To Maya Cullen  
From Growth Lancashire  
Subject Conservation Comments  
Date 25 April 2025

Ref: 3/2025/0086

**Proposal:** Listed Building Consent for removal of existing render including smooth rendered, surrounds, door surround and Quion feature to reveal stonework, raking out joints and pointing in lime mortar.

**Site Address:** 9 West View, Glen Avenue, Ribchester, PR3 2ZQ

Existing North West Elevation Proposed Elevation unchanged other than removal of render

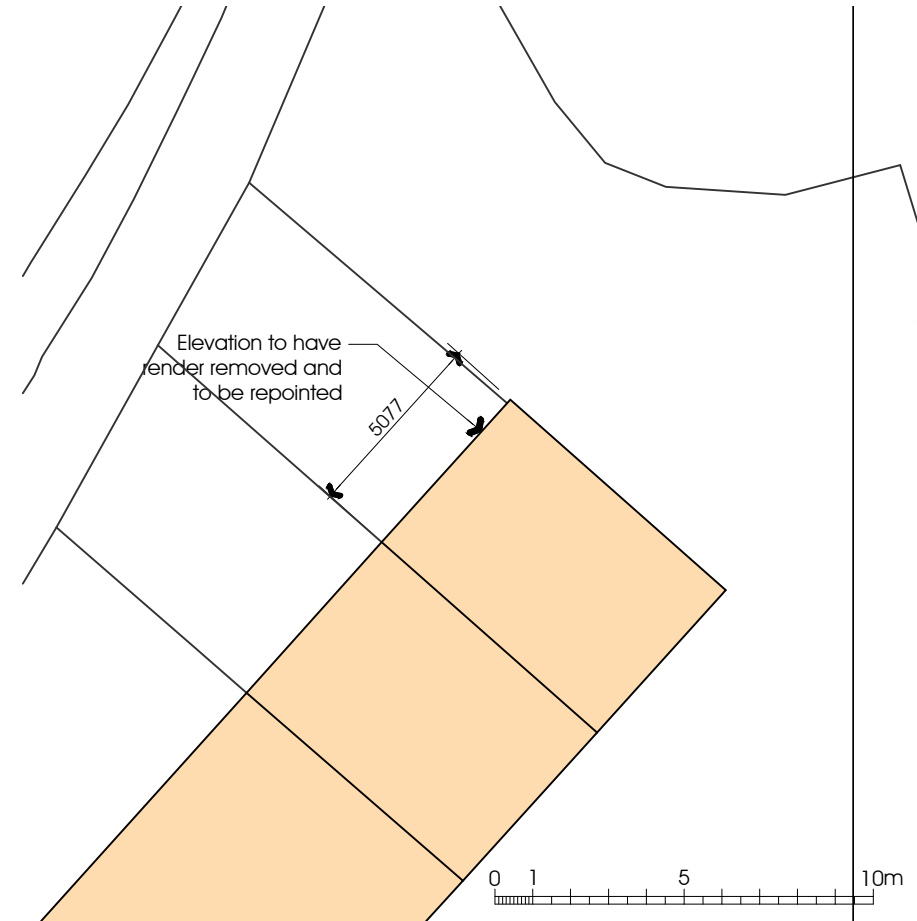
No.9 is the only property along the row that is rendered, with all other properties being of exposed stonework. It states that no.10 is believed to have had its front elevation render removed many years ago and there is evidence of the stone window surrounds possibly being keyed to receive the render. It is not stated as to when the render was applied to the building, but it is noted in the Heritage, Design and Access Statement that it is failing and is a cement render which restricts the breathability of the listed fabric. As such, I do not object to its removal.

Overall, I have no objections to the removal of the pebbledash render and rendered window/door openings and quoins. However, I feel that it would be more appropriate for an NHL2 to be used, as opposed to NHL3.5, as it is more flexible and vapour permeable and as such, would be a more appropriate. The use of NHL3.5 will cause slight harm to the listed building.

Subject to amendments (mortar) the scheme will meet the statutory duty to preserve and accord with Chapter 16 of the NPPF, meeting the requirements of local policy DME4. As noted above, I feel that an NHL2 should be used instead of

NHL3.5 to mitigate the slight harm identified. This could be dealt with via the use of a suitable Condition.
